From: Simon Davis
Sent: 03 January 2019 14:56
To: 'birol musa' [REDACTED]
Subject: RE: AW/331/18/DOC

WINDOW SECTION.

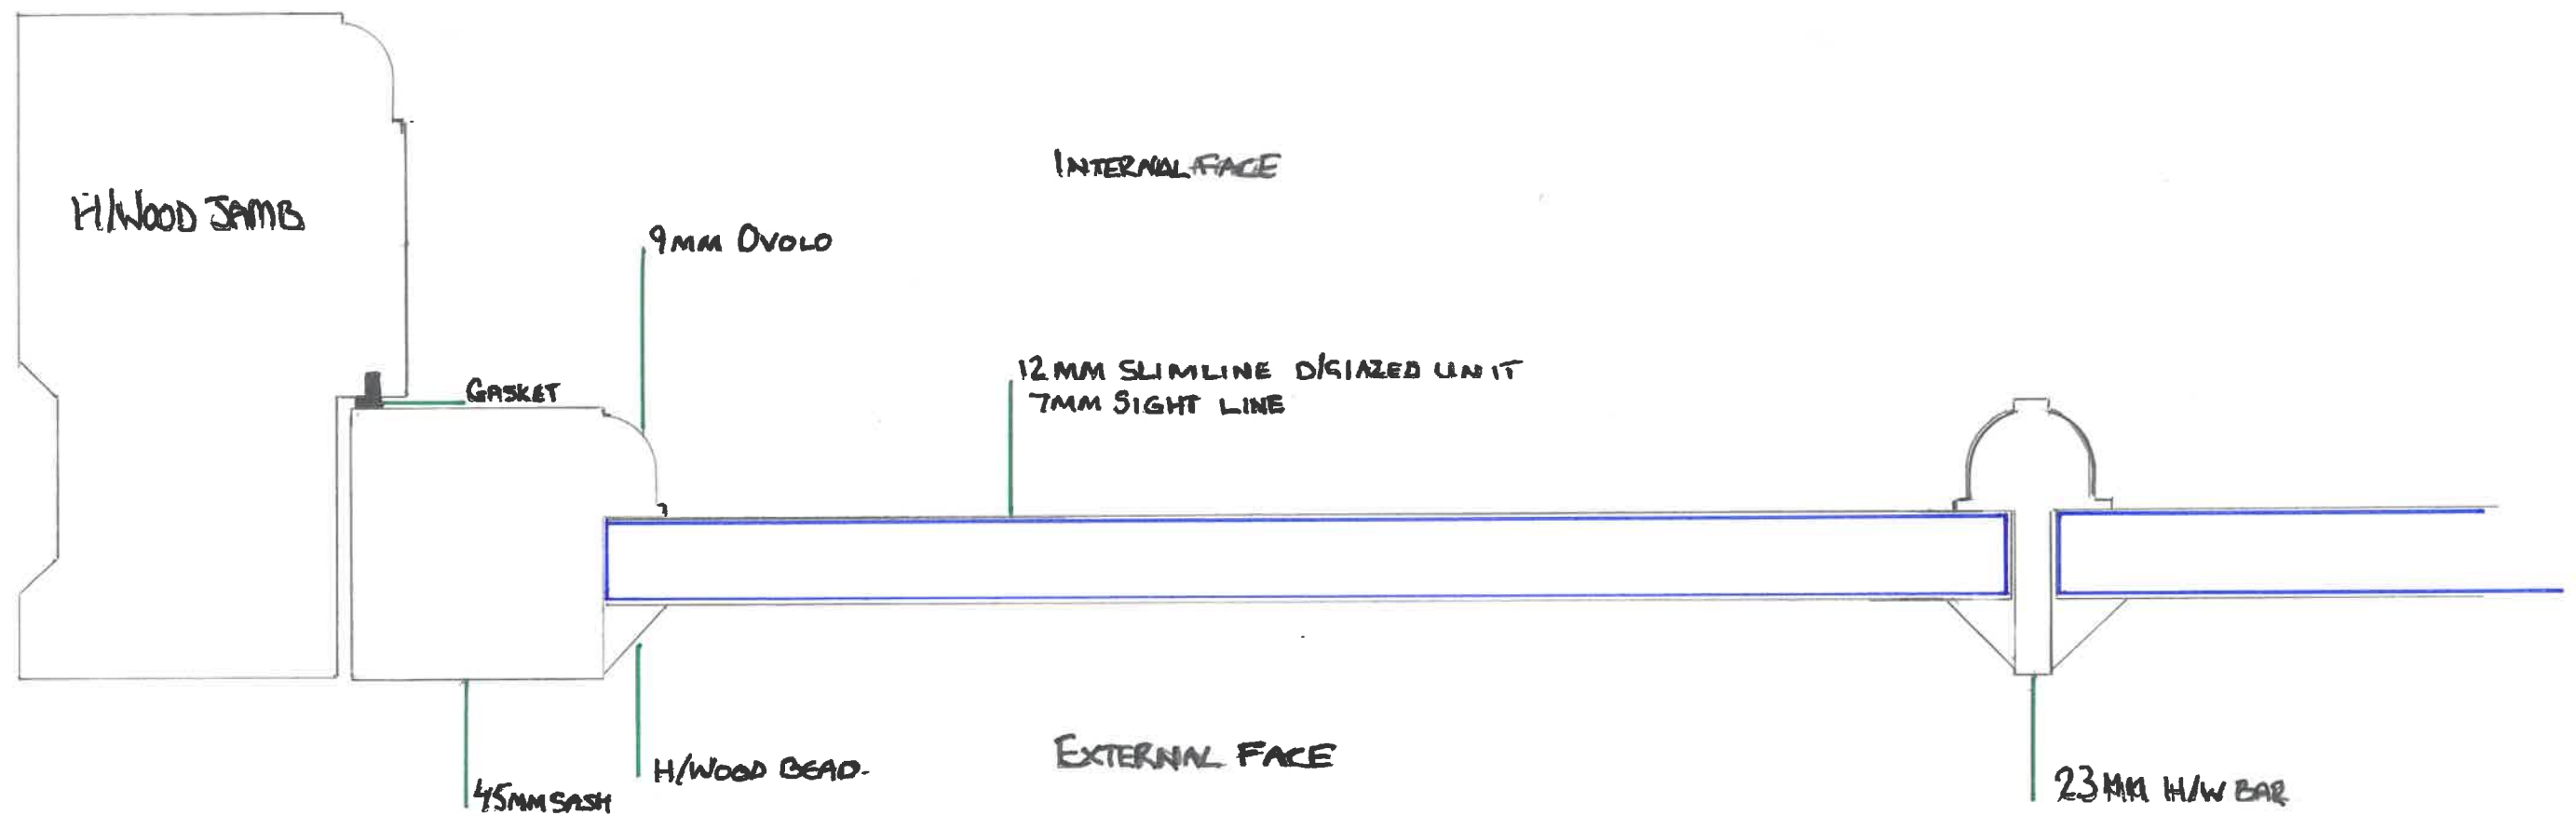
I have received the slate sample and the drawing. However, I have a couple of issue with the drawing. Firstly, it is marked as being 1:1 scale at paper size A3 but you have provided us with an A4 drawing so we would not be able to scale from it unless we enlarge the drawing (which can then throw the measurements out). Secondly, the drawing is really faint. We need to upload a copy to our website and I have so far been unable to scan it such that I can see the scanned image (I have tried in colour, B&W and have experimented with higher resolution settings. Can you comment please on the size of the drawing and whether a clearer/bolder drawing can be produced?
